# Boston Alternative Energy Facility

## Statement of Common Ground between Alternative Use Boston Projects Limited and Boston Borough Council

Planning Inspectorate Reference Number: EN010095

Date: ~~December 2021~~ February 2022

Key	
	Order limits
	Land outside Order limits
	Slope Protection
	Public Right of Way
	EXISTING VEGETATION (Existing vegetation within site to be enhanced)
PROPOSED FEATURES:	
	NATIVE SPECIES WOODLAND
	SCATTERED SCRUB PLANTING
	INDIVIDUAL TREE / HEDGEROW TREE PLANTING
	SPECIES RICH GRASSLAND

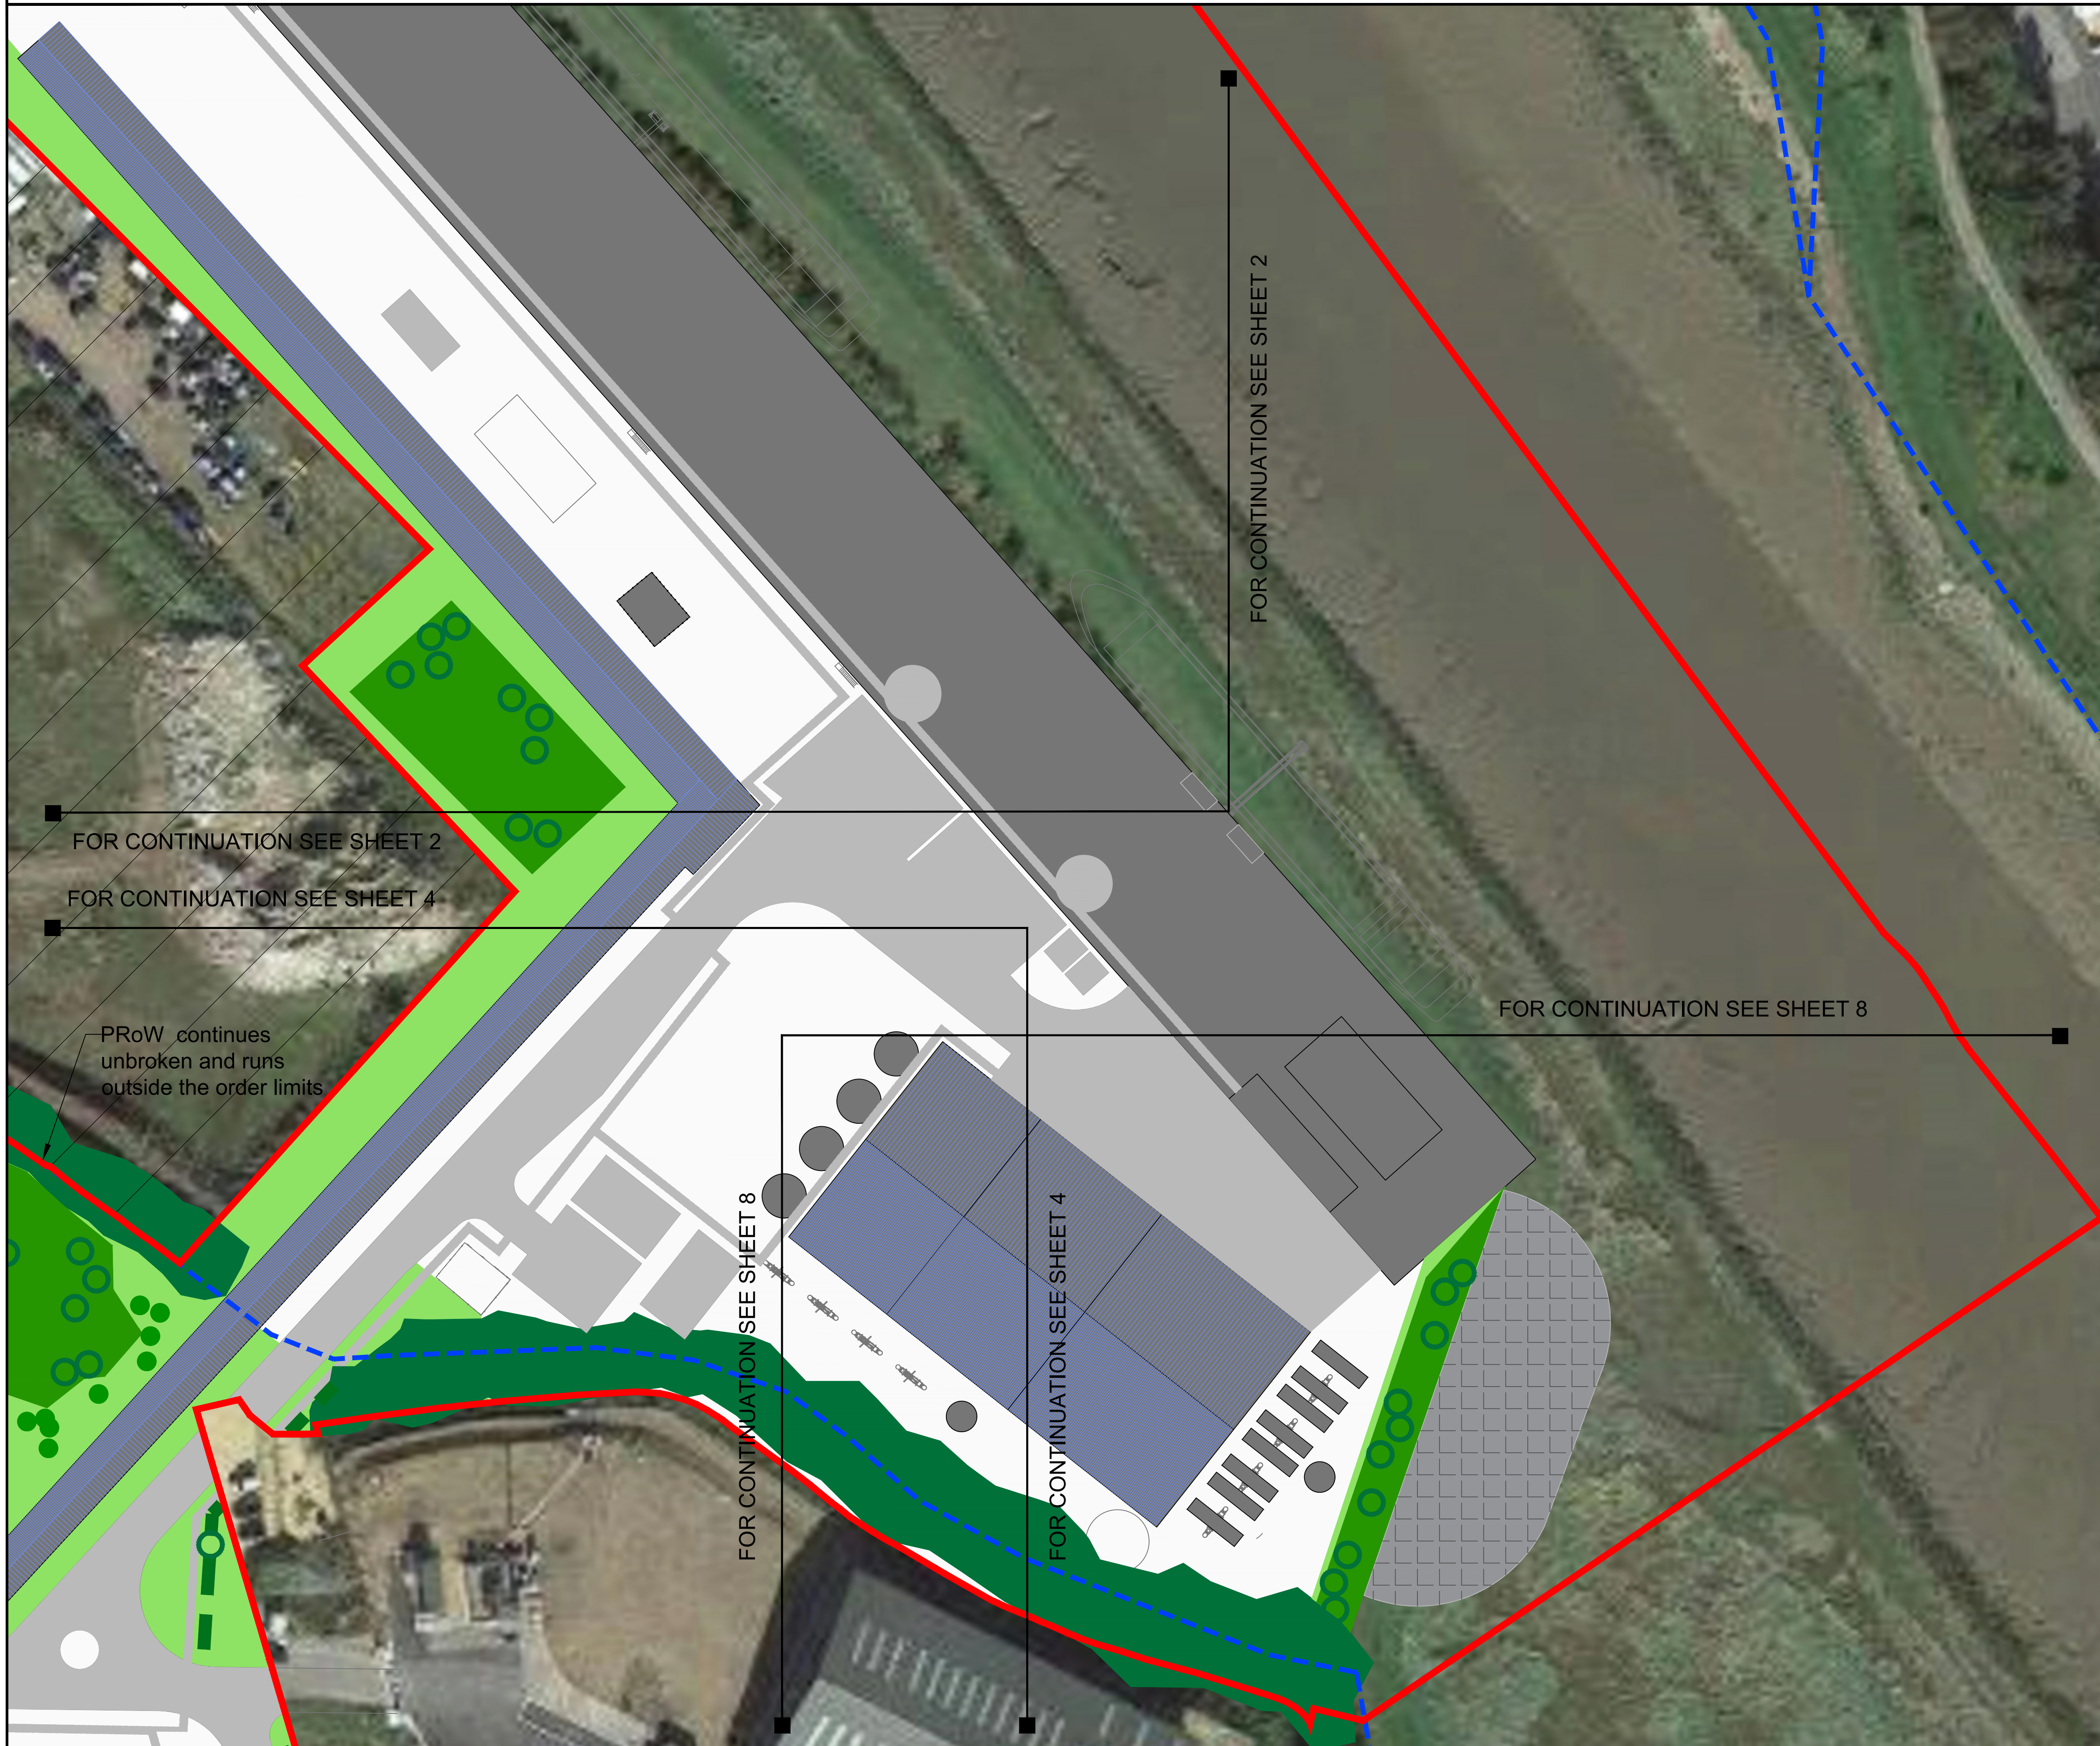
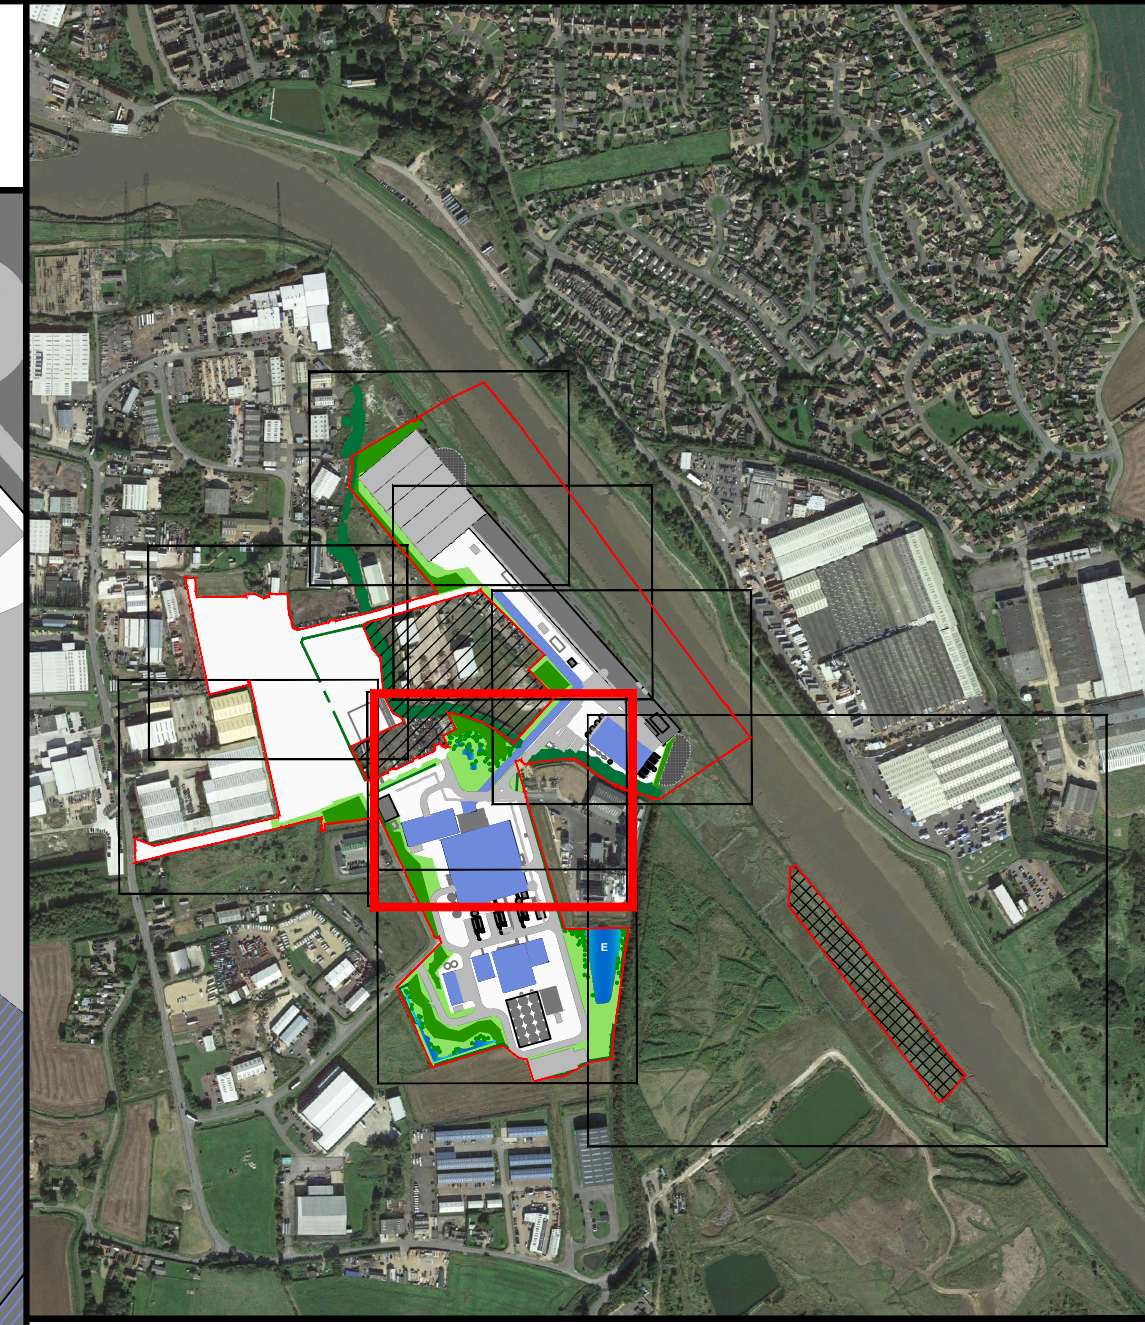
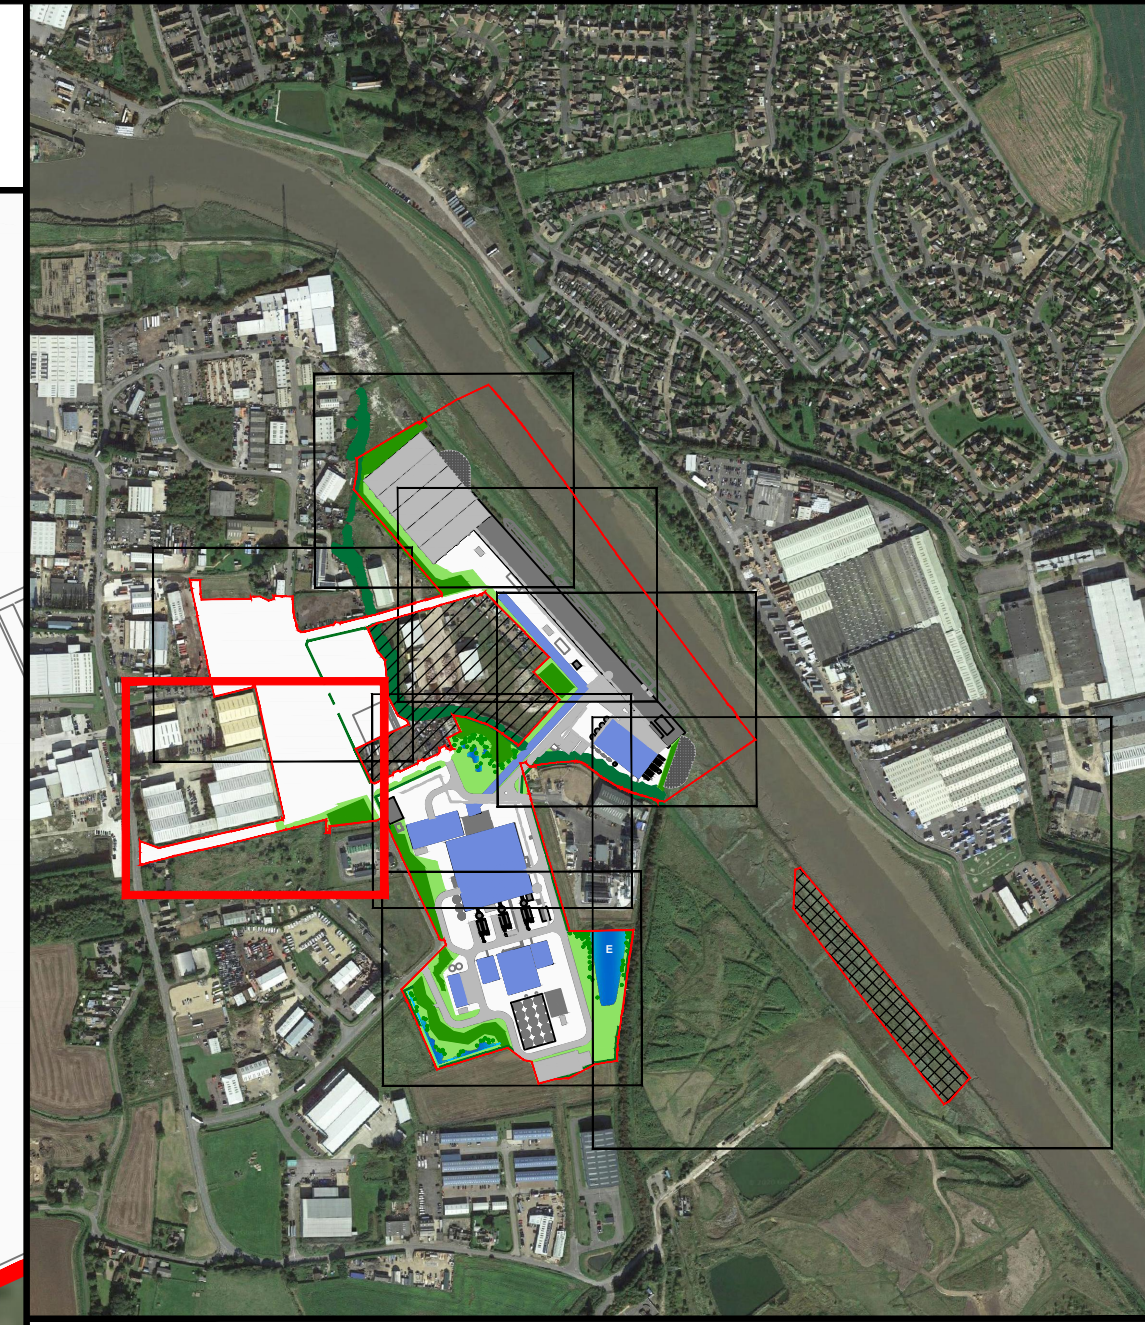
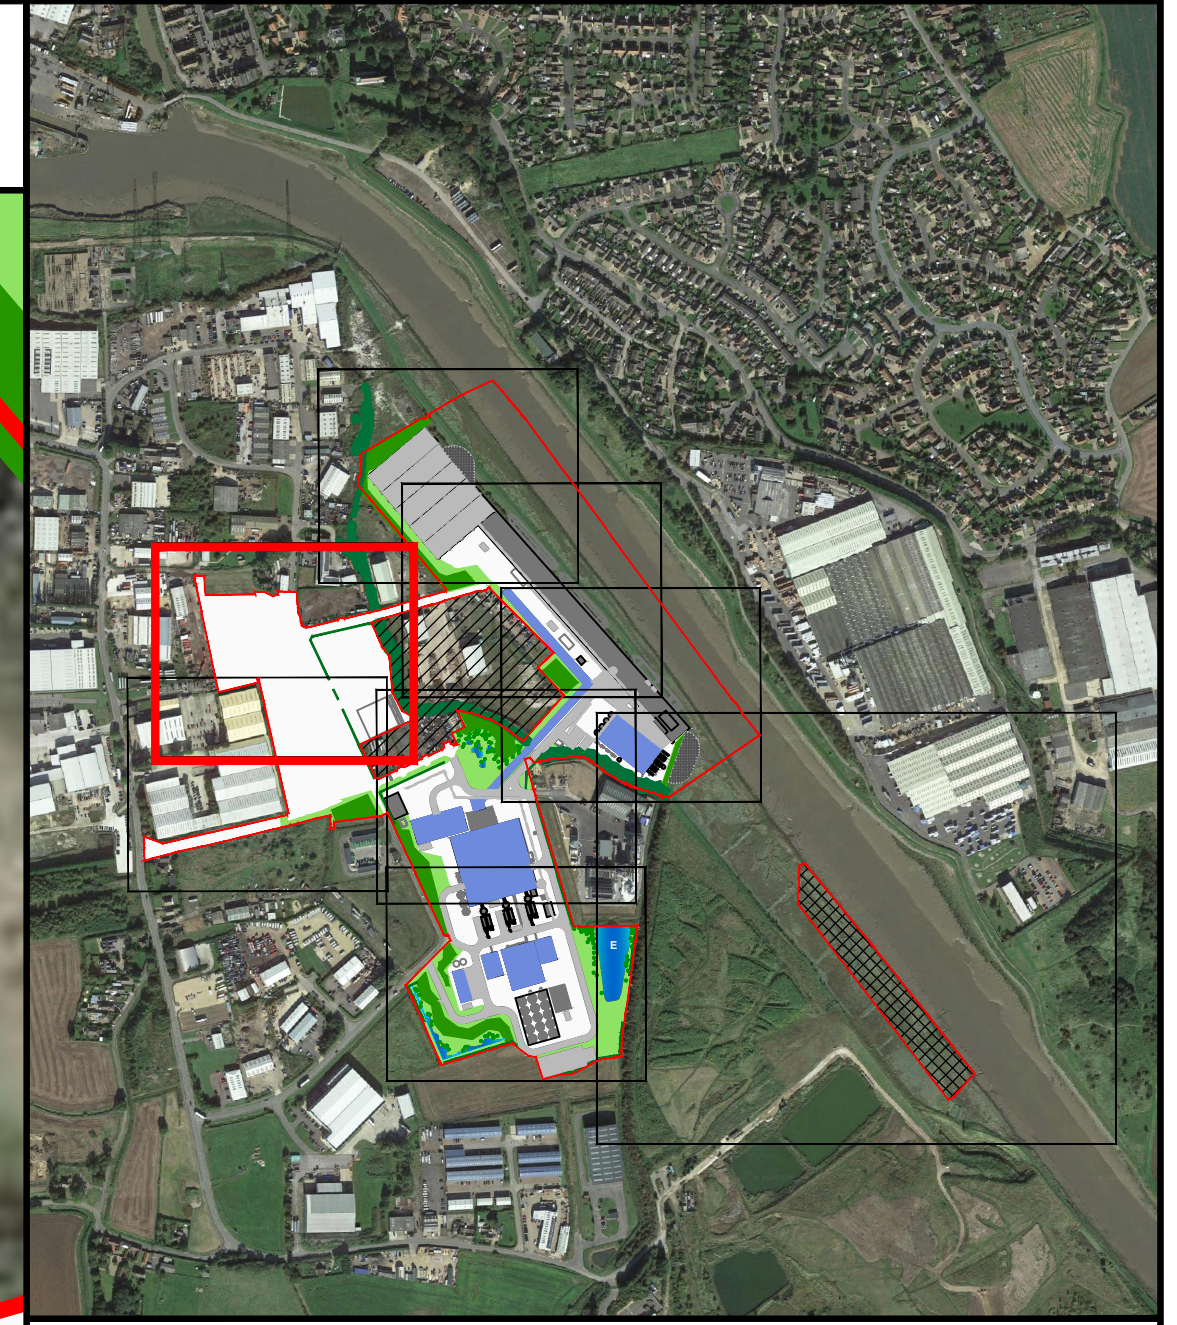
SoCG Reference	Document Reference	Topic	BBC's Position	AUBP's Position	Status
			submissions have been lodged formally, and a S106 concluded.		
BBC 2.4	Outline Landscape and Ecological Management Plan (Doc ref 7.4, APP-123)	Planting	<p>Planting should be moved forward in the programme and inspections should be carried out more frequently than annually. The planting proposed is described in the OLEMS could be adjusted to provide enhanced carbon and particulate removal.</p> <p>The Council has reviewed the responses to date on this point. We note the steps taken by AUBP to address and that there are proposals for mitigation being presented. In general terms these are acceptable. There are some inconsistencies in the document –            Para 10.7.2 does say monthly inspections. There are instances in paras 10.8.2, 10.10.2 10.11.2 that refer to annual removal of rubbish and repair of vandalism so my be inconsistencies that need reviewing.</p> <p>It is likely that this matter will be agreed by a subsequent deadline once further submissions have been lodged formally, requirements finalised, and a S106 concluded.</p>	<p>The updated OLEMS was submitted to the Examination at Deadline 3 (document reference 7.4(1), REP3-007), includes a monthly inspection of vandalism and fly tipping. Any inconsistencies in the OLEMS will be checked and amended as necessary.</p> <p>The Applicant will agree the final planting within the final LEMS.</p>	Under discussion
